**DEVELOPMENT REVIEW BOARD
AGENDA**

- 1. Project# 1009923**
14DRB-70095 EPC APPROVED SDP FOR
BUILD PERMIT

RIO GRANDE ENGINEERING agent(s) for X-
FACTOR INC request(s) the above action(s) for all or a
portion of Lot(s) 1, Block(s) 13, **CARLISLE
PLAZA ADDITION** zoned SU1 FOR CHURCH,
located on MONTCLAIRE BETWEEN CANDELARIA
AND VALVERDE containing approximately .6887
acre(s). (G-17) **THE SITE DEVELOPMENT PLAN FOR
BUILDING PERMIT WAS APPROVED**

Project Name: Carlisle Plaza Addn

<b>X-FACTOR</b> AMENDED SITE PLAN FOR BUILDING PERMIT	DRAWN BY WCUJ DATE 2-26-14 21350-LAYOUT-12-01-13
		SHEET # 1 JOB # 21350
DAVID SOULE P.E. #14522	 <b>Rio Grande Engineering</b> 1806 CENTRAL AVENUE SE SUITE 201 ALBUQUERQUE, NM 87106 (505) 872-0999

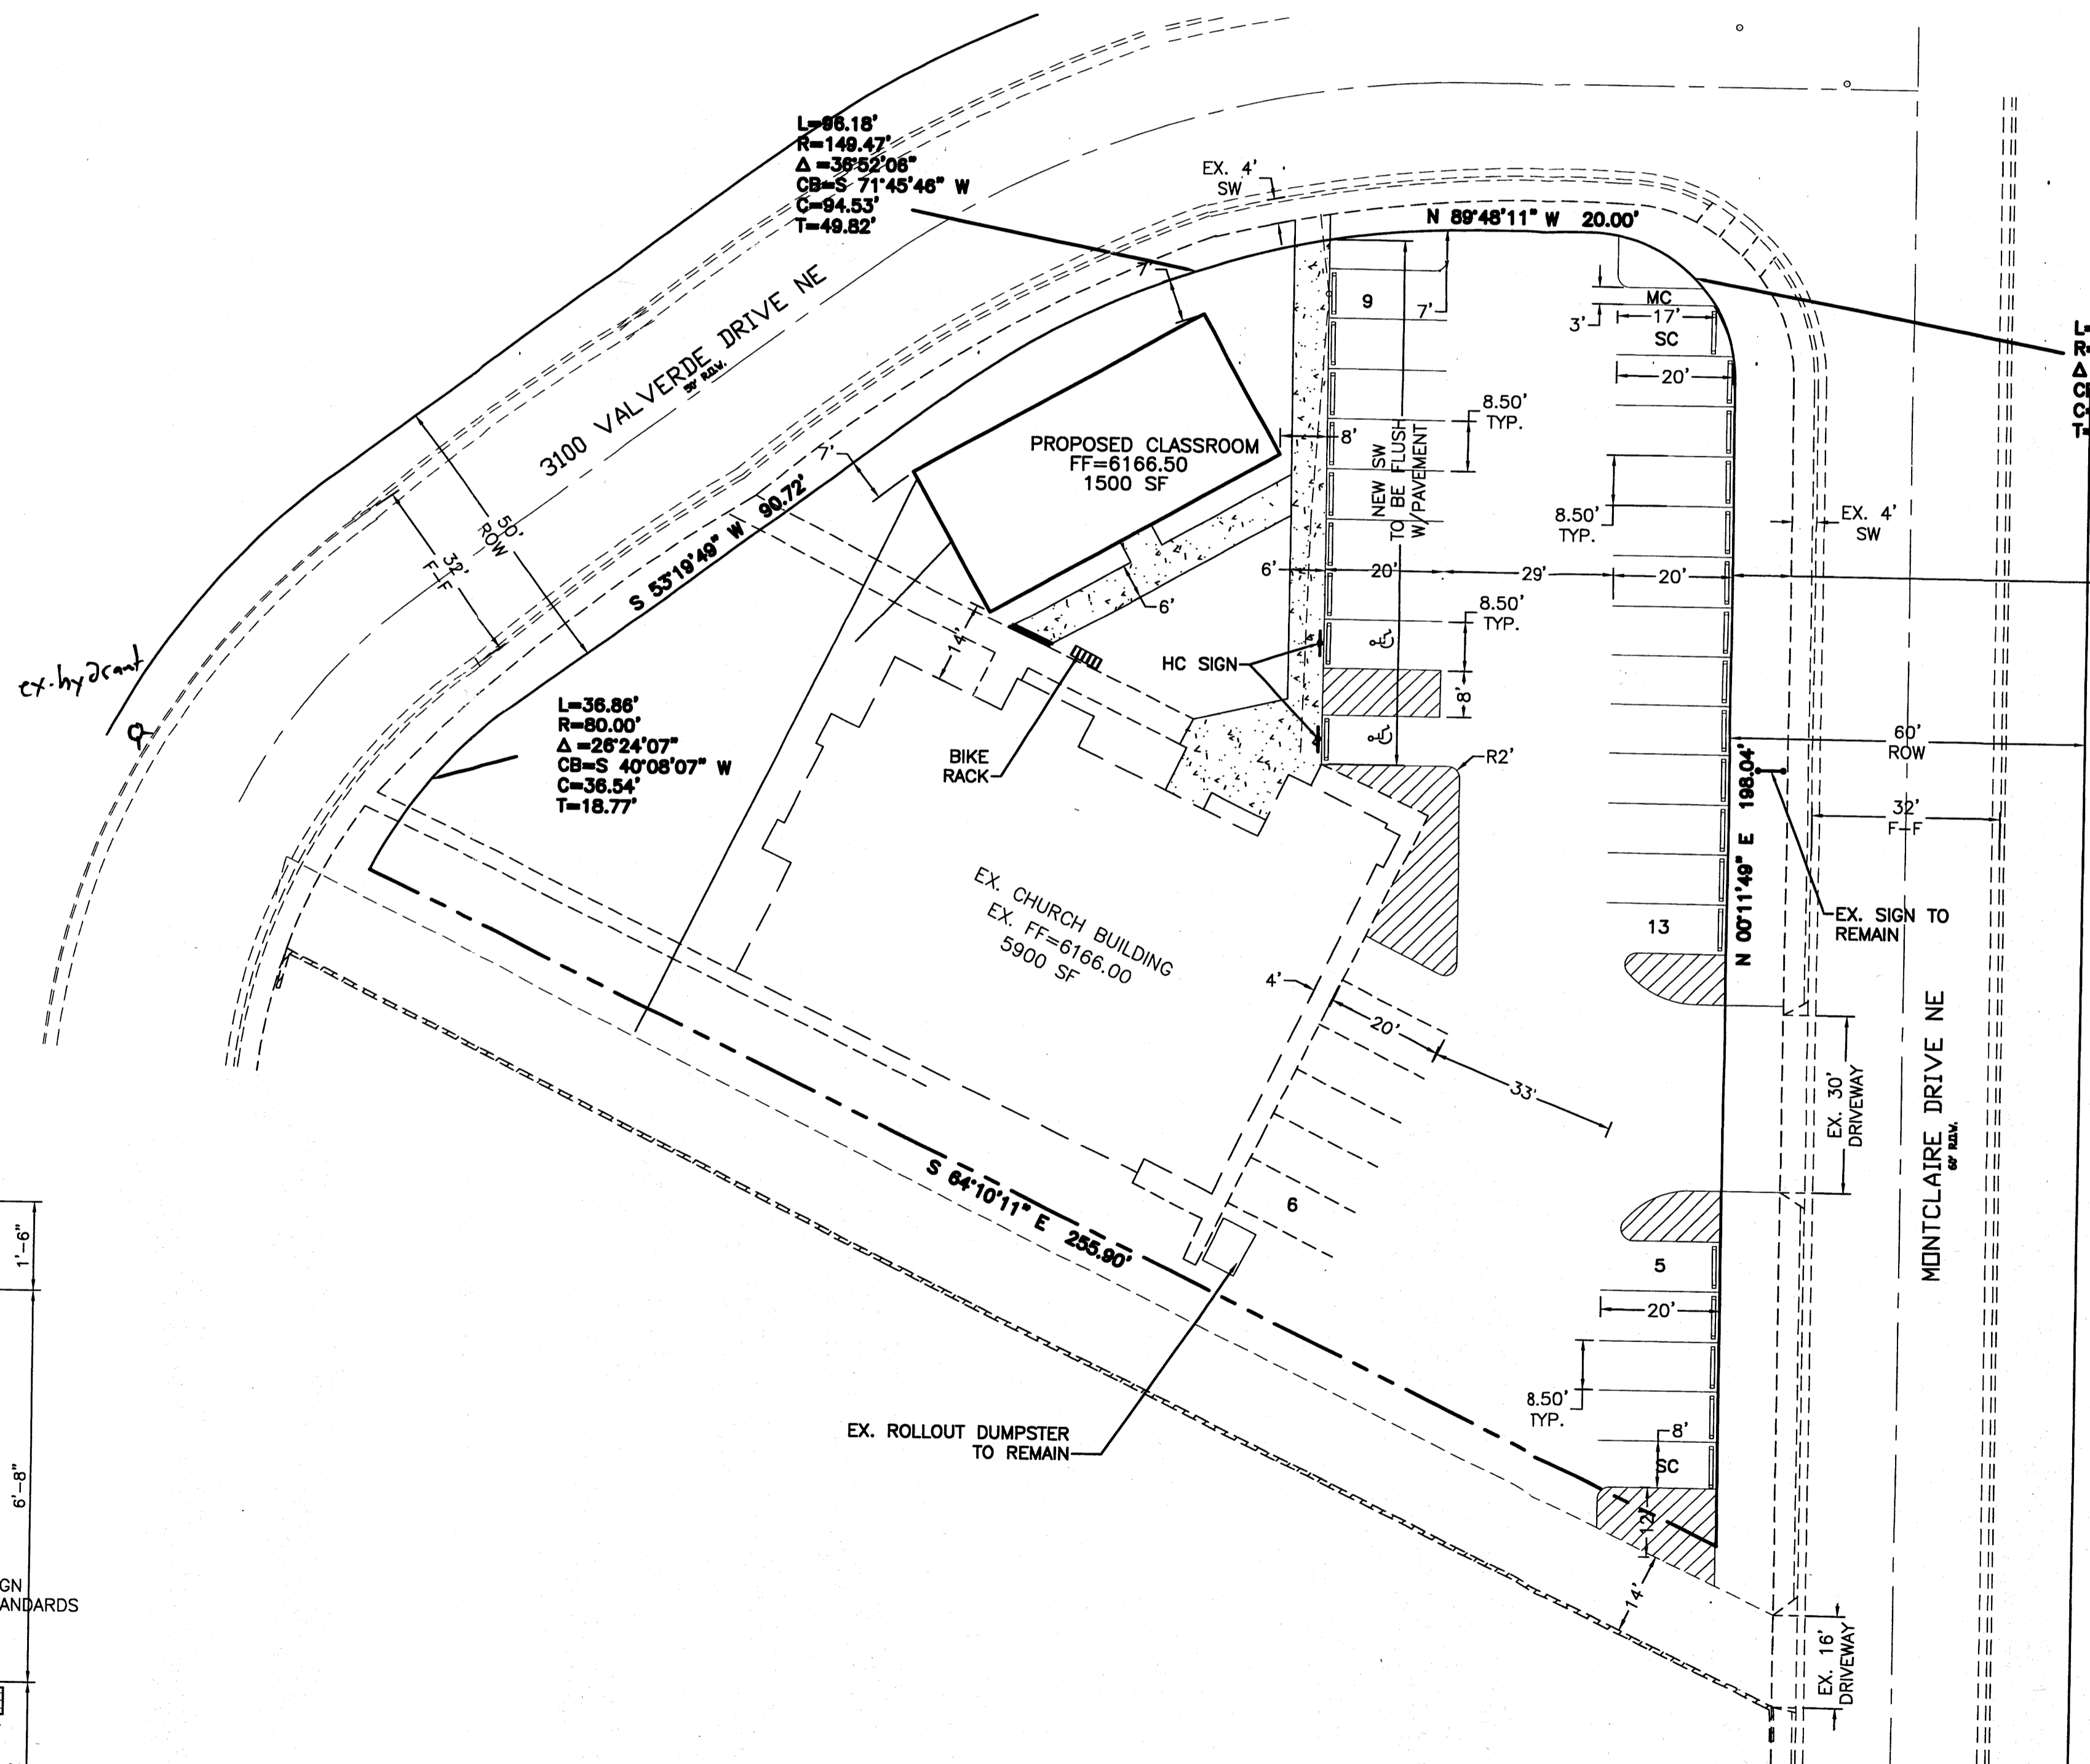
Condition of Approval #2 states “Add the following note to the General Notes and Landscaping Plan: “Landscaping, fencing and signing will not interfere with clear sight requirements. Therefore, signs, walls, trees, and shrubbery between 3 and 8 feet tall (as measured from the gutter pan) will not be acceptable in this area.” The note was added to the Landscaping Plan, but not on Sheet #1 under General Notes. Could you resend Sheet #1 with the clear sight language? Would it be possible for you to get that to us today?

I have added as note #3 on sheet one. I will replace old sheet with this if acceptable

LANDSCAPE PLAN

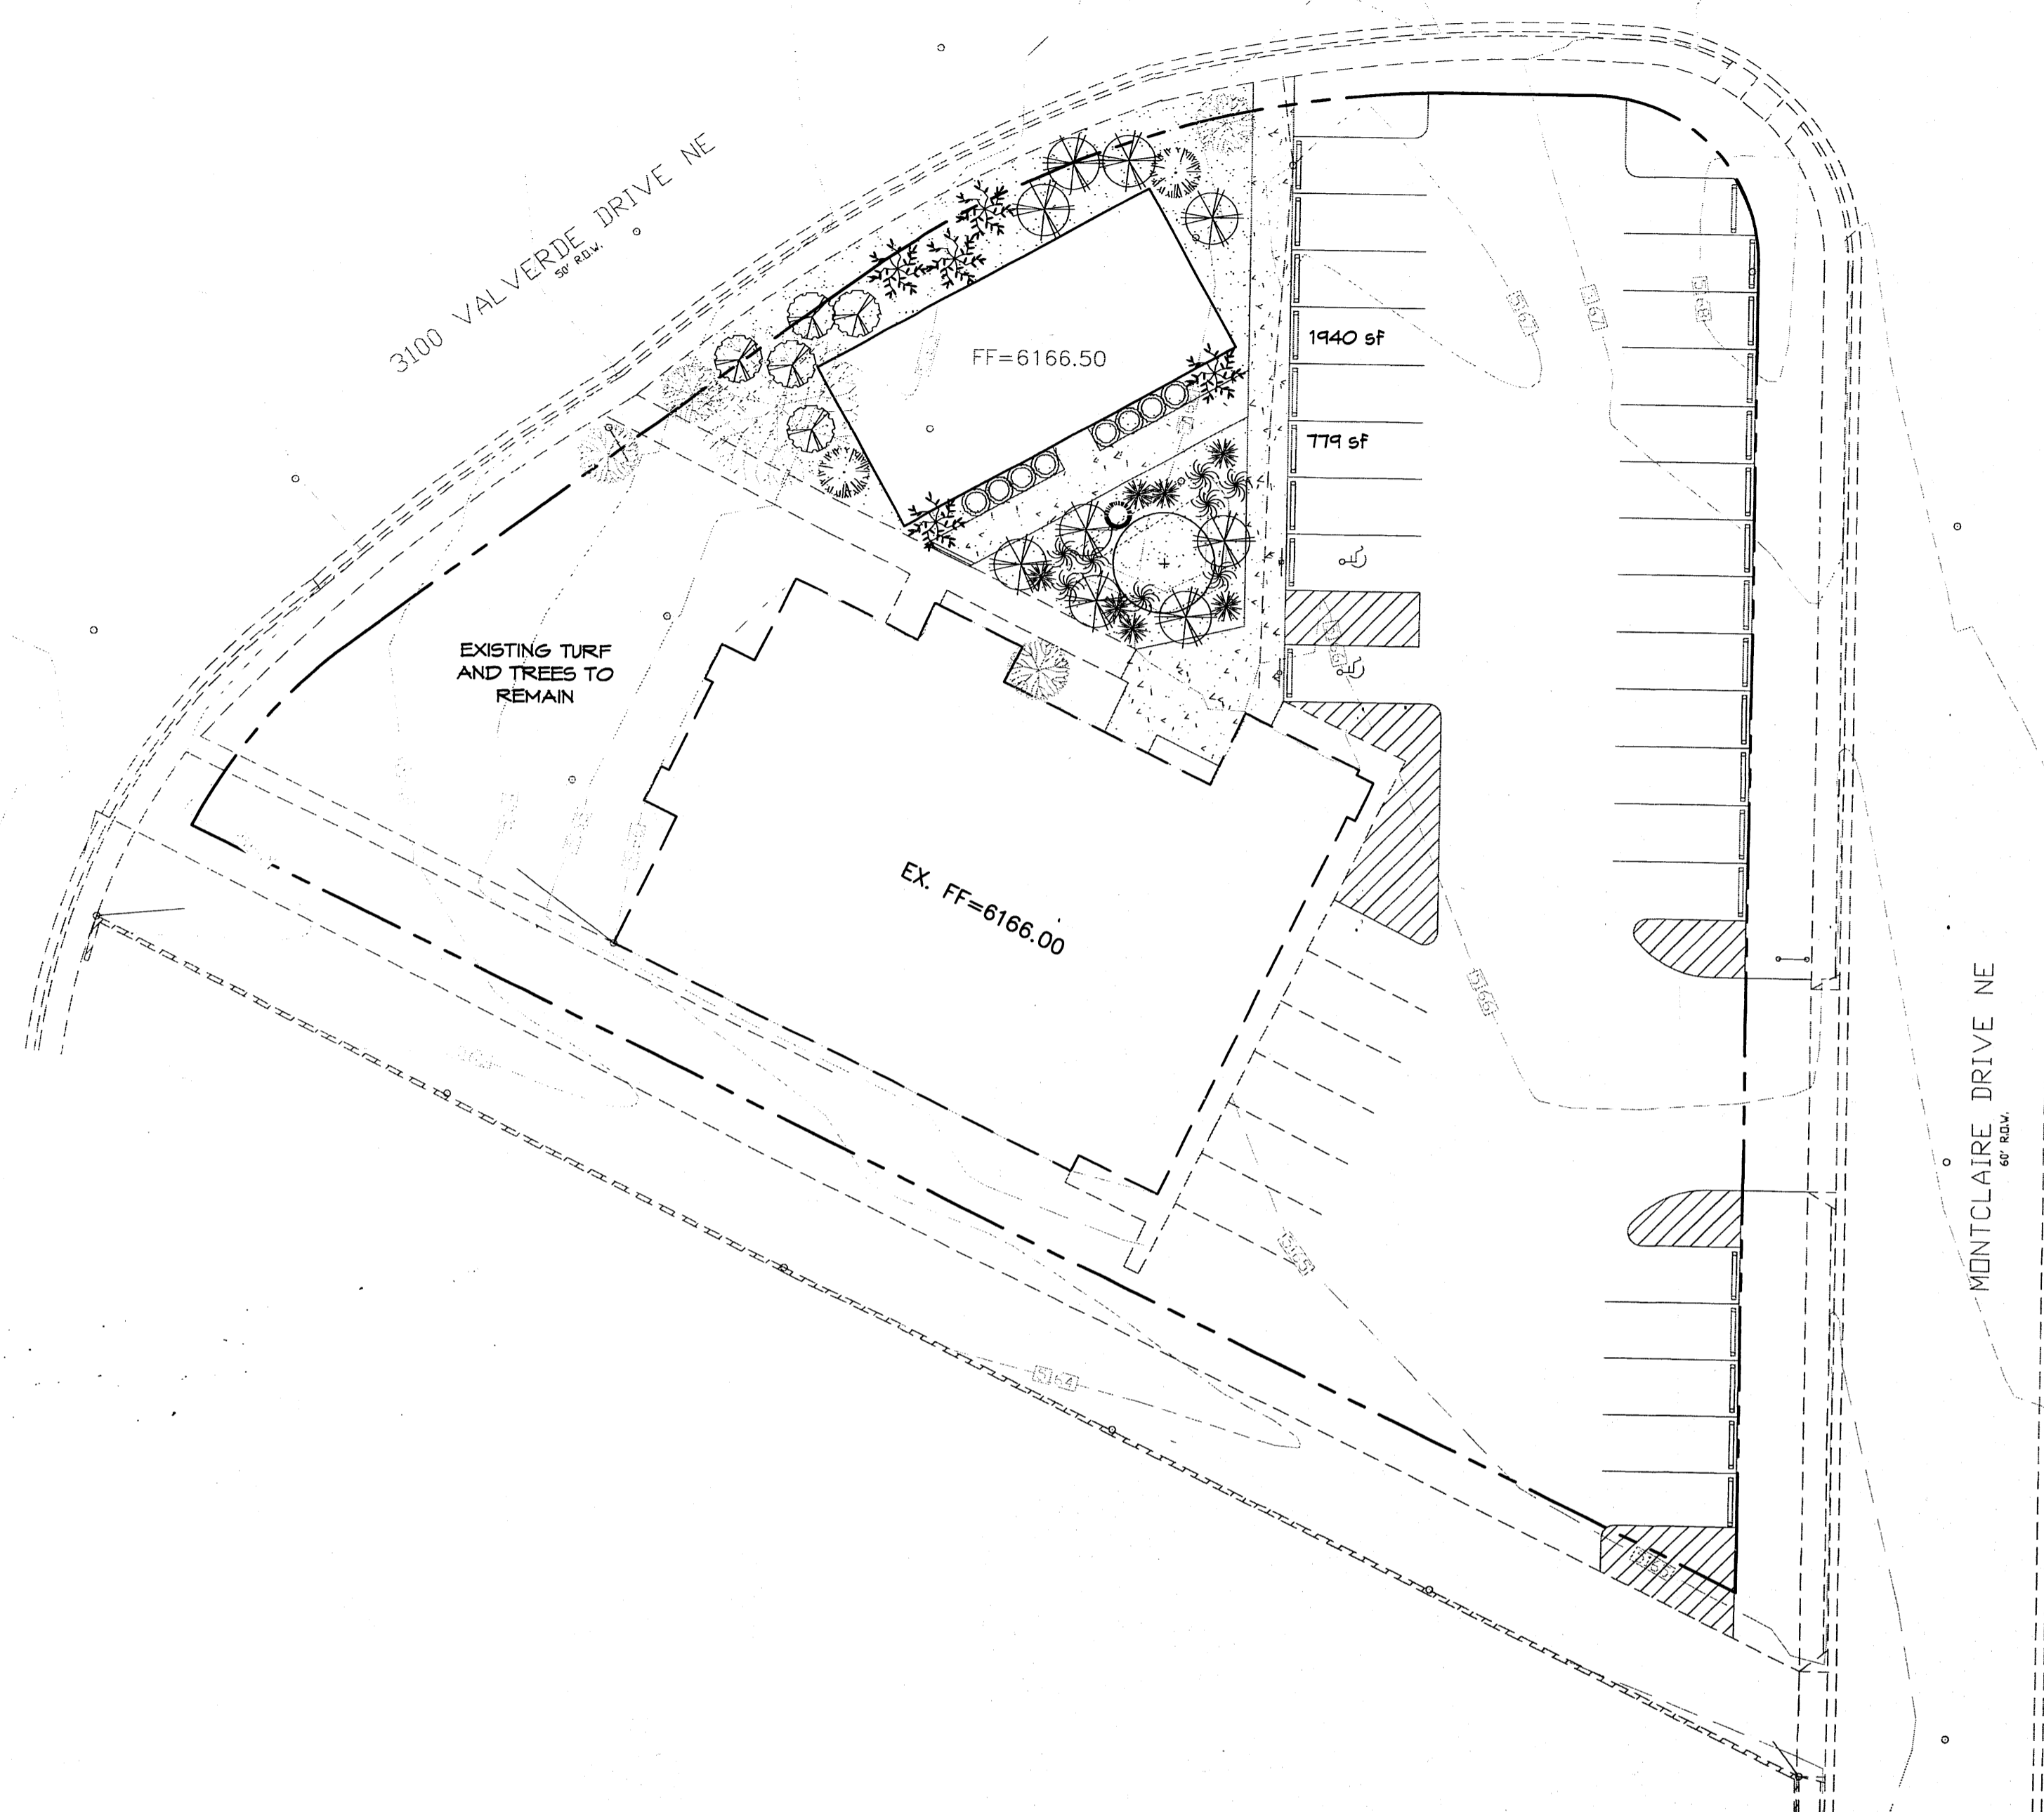
2. **Add the following note to the General Notes and Landscaping Plan: "Landscaping, fencing and signing will not interfere with clear sight requirements. Therefore, signs, walls, trees, and shrubbery between 3 and 8 feet tall (as measured from the gutter pan) will not be acceptable in this area."**

We have added this note the landscape plan.
